Application No: CM/48/21/RES
Site Address: Land to the West of Church Lane South of Horsemere Green Lane Climping
Description of works: Approval of reserved matters following the grant of CM/1/17/OUT for the erection of 300 No dwellings & a building within use class E, together with public open space, LAPs, LEAP & ancillary works, including car parking & drainage arrangements, with access off Church Lane & Horsemere Green Lane. This application may affect the setting of listed buildings & is in CIL Zone 4 (HSP2) & is not CIL Liable.

Thank you for your internet representation made on 7th October 2021 which has been recorded as an objection with the comments as follows:

I would like to raise several concerns regarding the proposals contained in the Construction Method Statement:

3. Construction Traffic Route

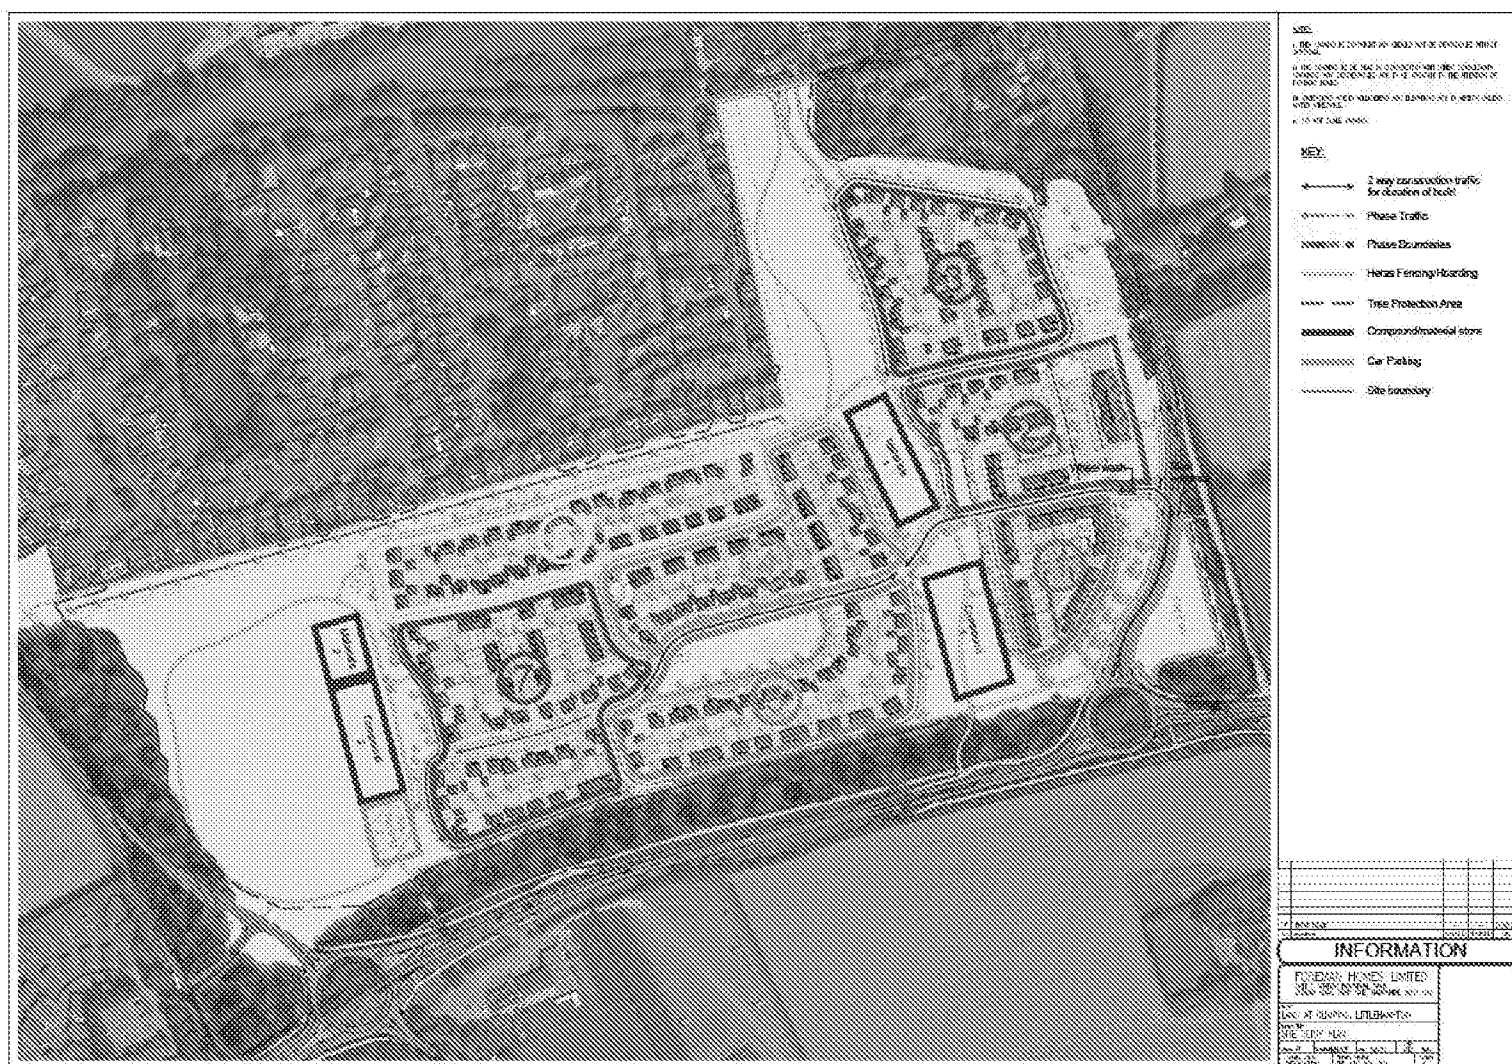
Proposed temporary access off Horsemere Green Lane - the period of use is not defined or time limited. Horsemere Green Lane is a narrow road, which experiences congestion in the peak hours. No information on mitigation measures is provided other than road sweeping. Also, it is unclear how the footway will be protected from vehicles and how delivery vehicles will be managed;

Proposed highway works to create new access - the timing of the works is not well defined and I am concerned that Horsemere Green Lane could be used for a longer period than necessary;

New highway access - how will the applicant ensure that deliveries do not use Horsemere Green Lane as a shortcut. Also, what is the proposed traffic management during construction of the access and realignment of Church Lane?
